CITY OF PORTLAND BUILDING PERMIT

Located At 71 BANCROFT ST

Job ID: 2012-10-5284-ALTR

has permission to Expand rear landing & replace front entry creating an enclosure (Single Family Residence).
provided that the person or persons, firm or corporation accepting this permit shall comply with all of the provisions of
the Statues of Maine and of the Ordinances of the City of Portland regulating the construction, maintenance and use of
the buildings and structures, and of the application on file in the department.

71 BANCROFT
ABUTTING PROPERTIES

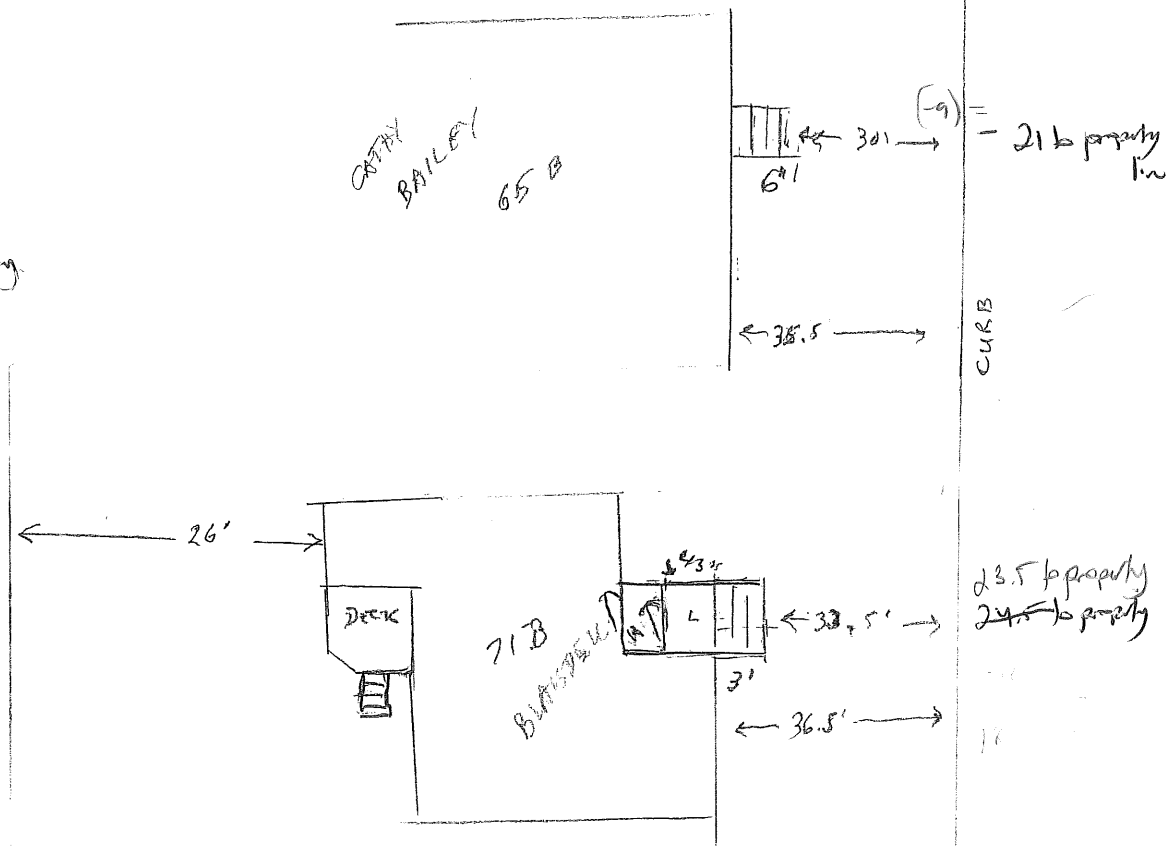
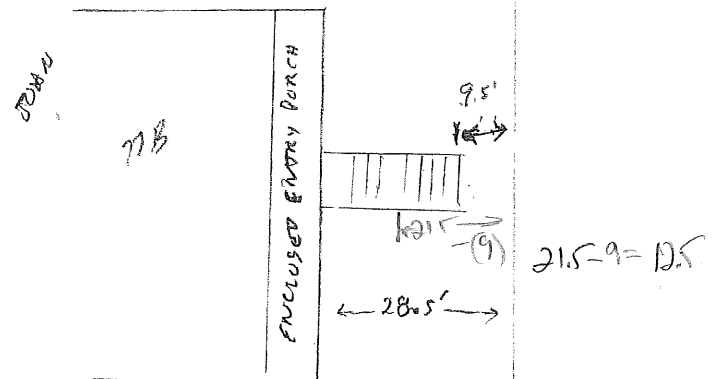
3. This property shall remain a single family dwelling. Any change of use shall require a separate permit application for review and approval.
4. The exact front setback to the proposed new landing & stairs is unclear. The minimum front yard setback is 25' or the average of the front yards of the houses on either side which was not provided. If the new 6' x 4' landing and stairs does not meet the 25' front setback, it is being approved under section 14-425. The landing & stairs must not extend more than six feet off the building and the footprint may not be larger than 50 square feet. Also, the new landing may have a roof over it but it cannot be enclosed if it encroaches into the front yard setback. If it meets the average front setback of the houses on either side, then it can be enclosed.

Sample of roof extending out over landing stairs.

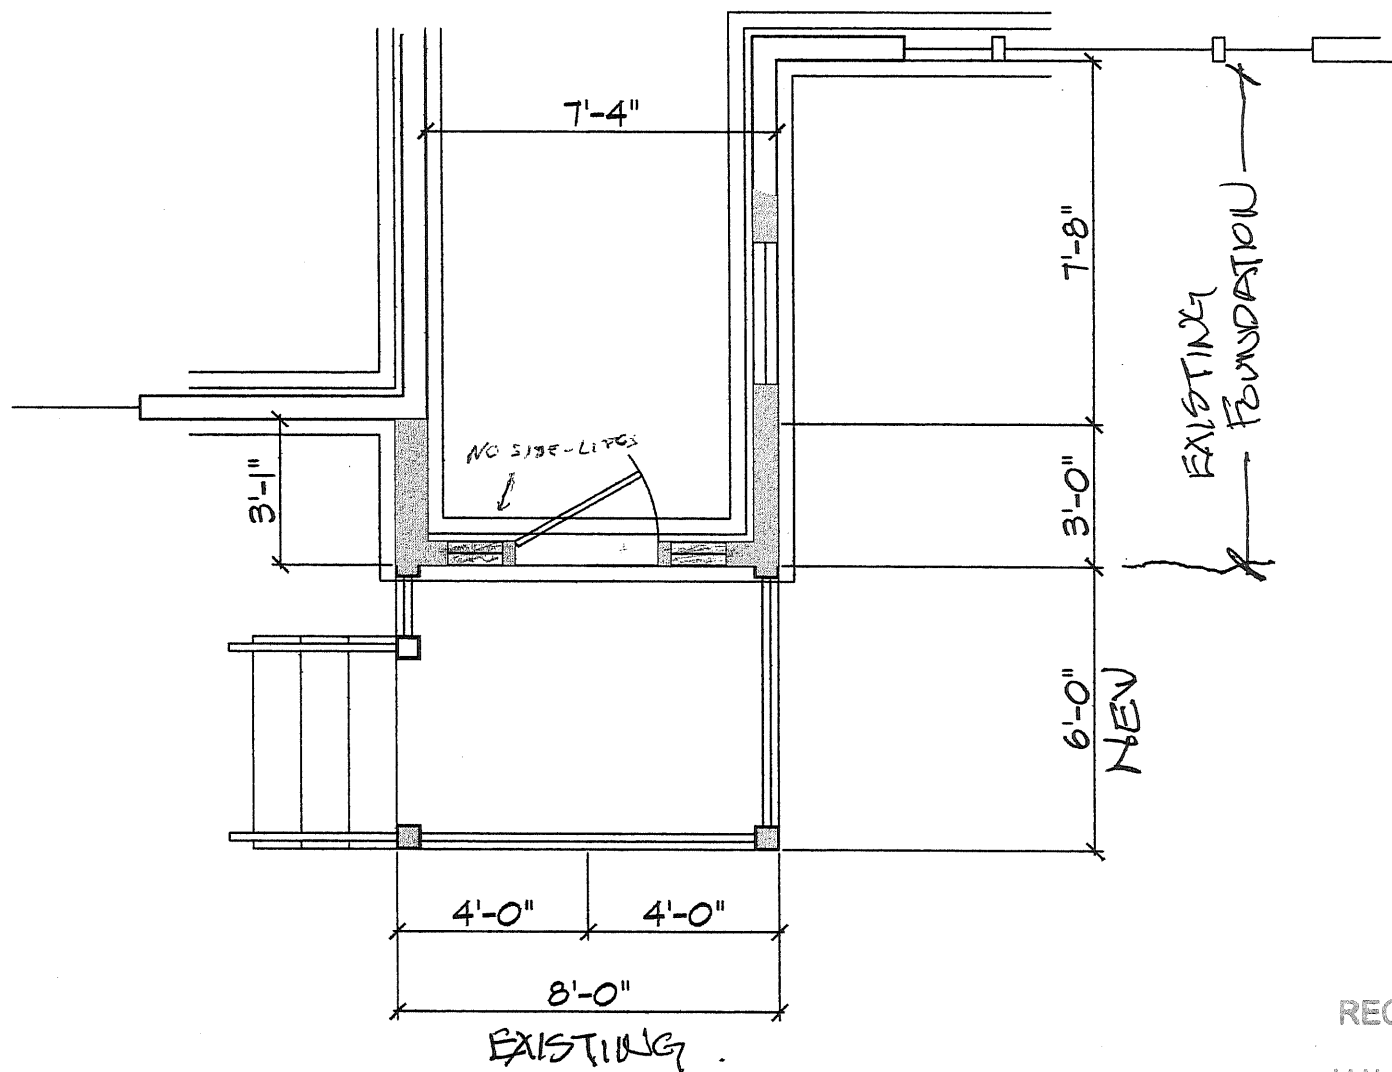
5. R312.3 Opening limitations. Required guards shall not have openings from the walking surface to the required guard height which allow passage of a sphere 4 inches in diameter.
6. The maximum riser height shall be 7 3/4 inches; the minimum tread depth shall be 10 inches.
7. Stairway headroom shall be not less than 6 feet 8 inches measured vertically from the sloped plane adjoining the tread nosing or from the floor surface of the landing or platform.
8. R311.7.1Width. Stairways shall not be less than 36 inches in clear width at all points above the permitted handrail height and below the required headroom height.
